Two new rooms in roof with new shower room and internal adaptations to the ground floor
1 Surrey Wharf Arundel

Thank you for your internet representation made on 27th February 2013 which has been recorded as '**an objection**' with the comments as follows:

Objections to the Planning Application

Proposed plans & elevations

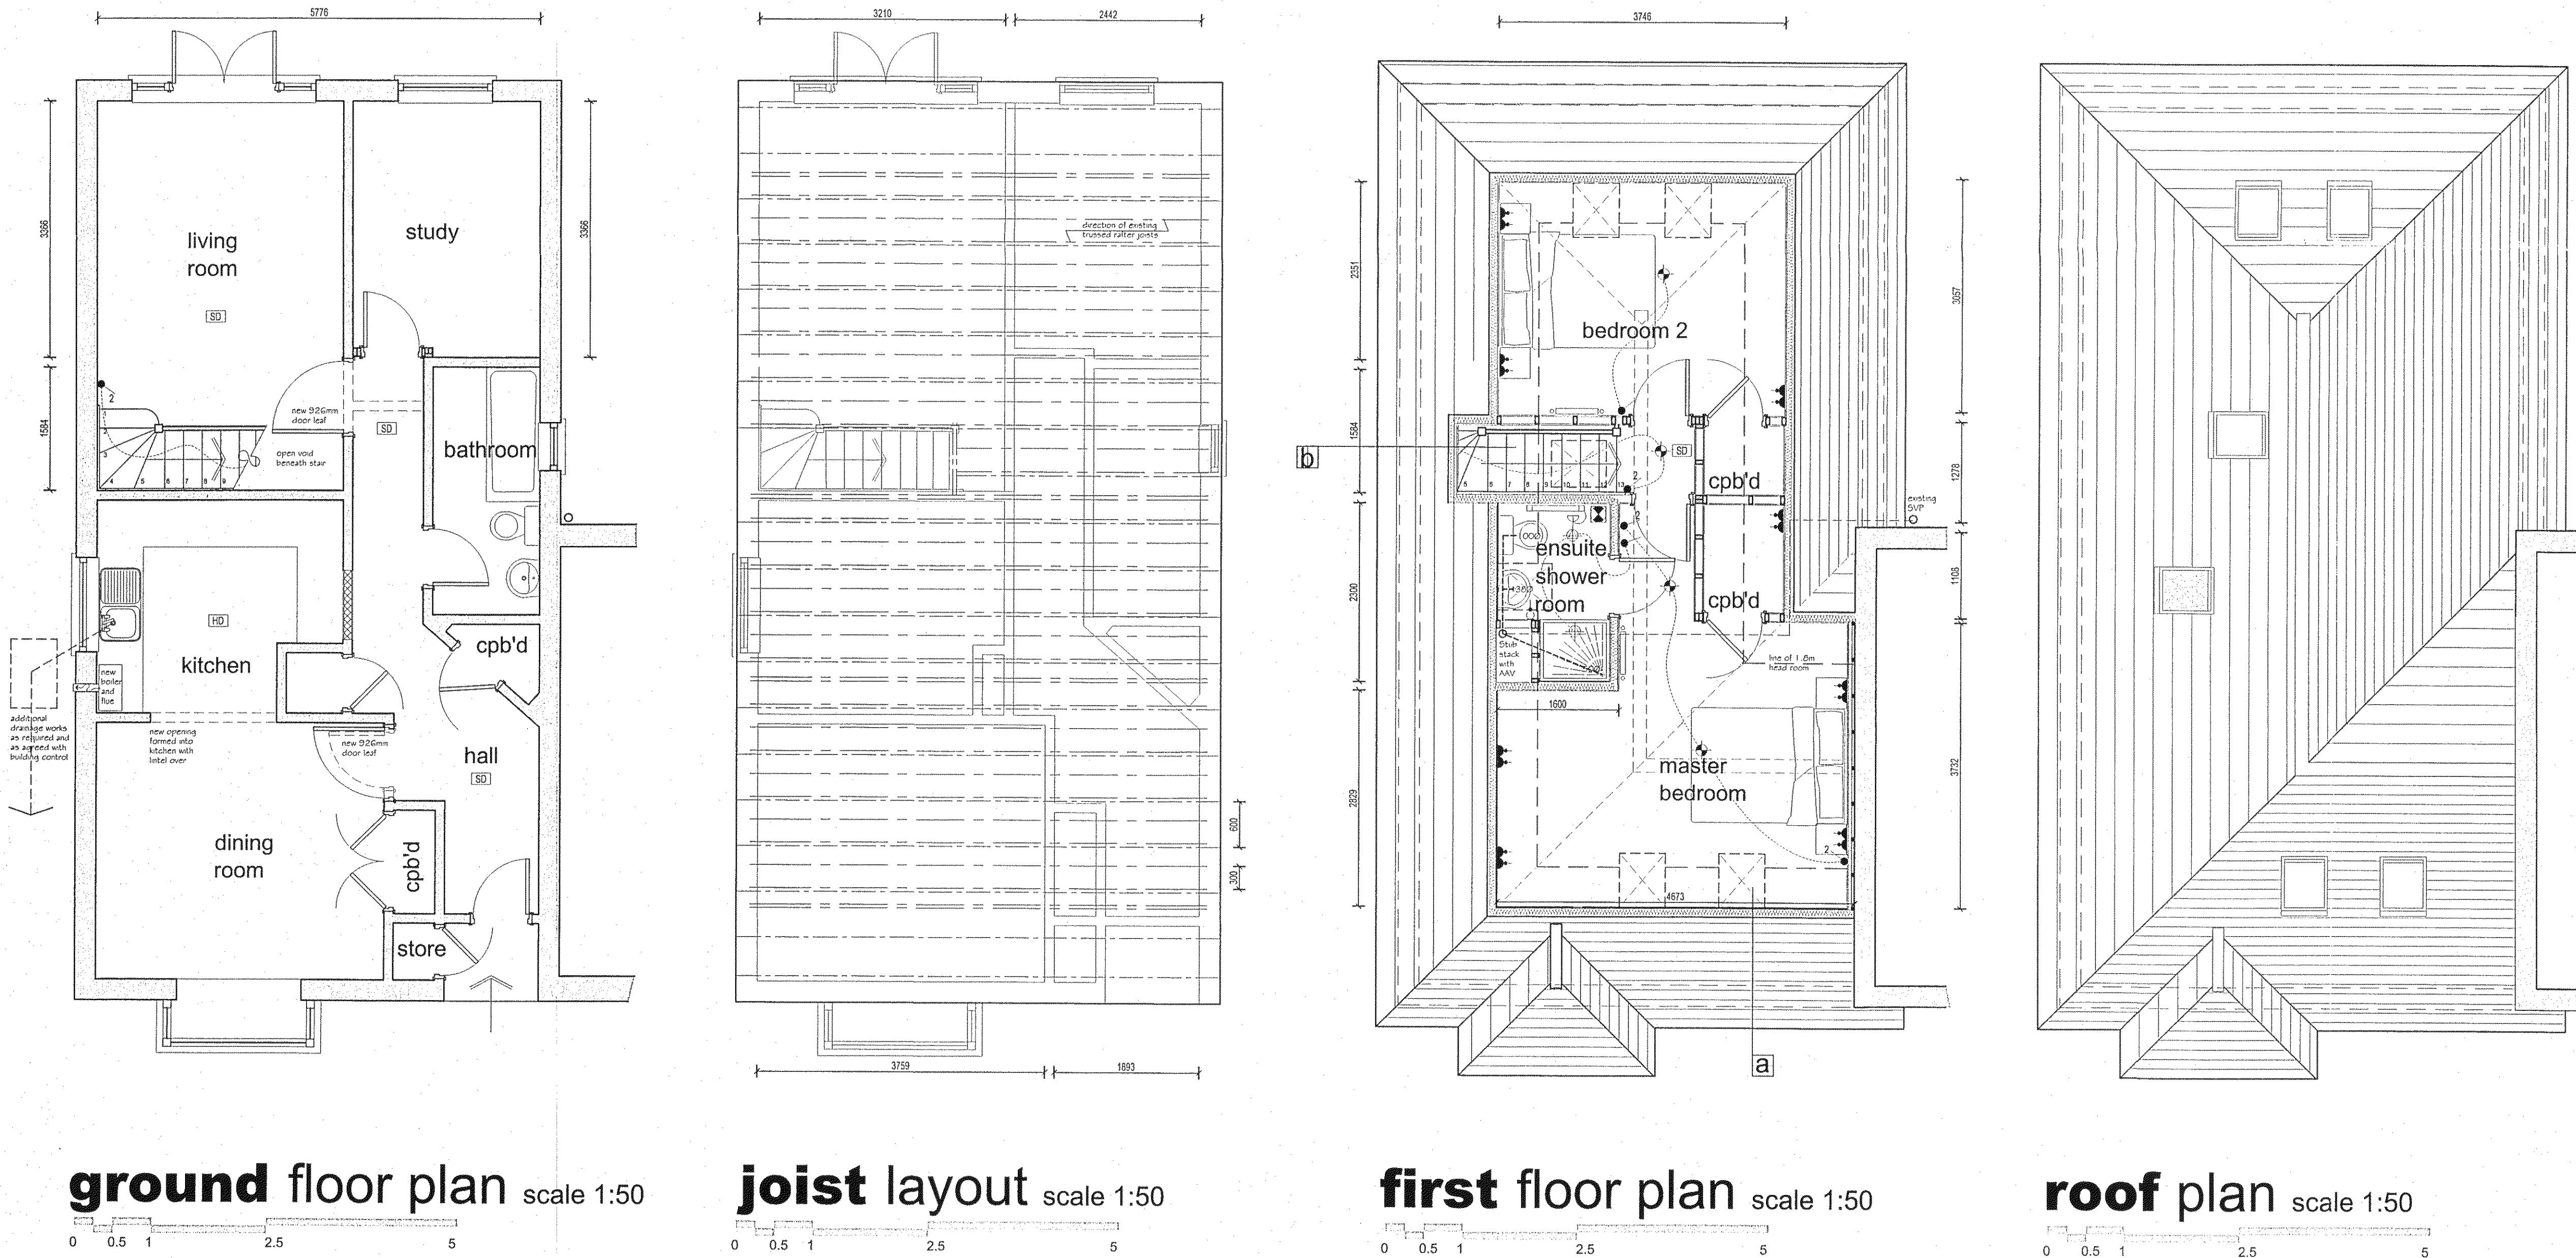
1. *Windows overlook our property - plans state frosted but what is to stop this from being swapped out?*

5. *UPVC - windows as this would set a president in the local conservation area*
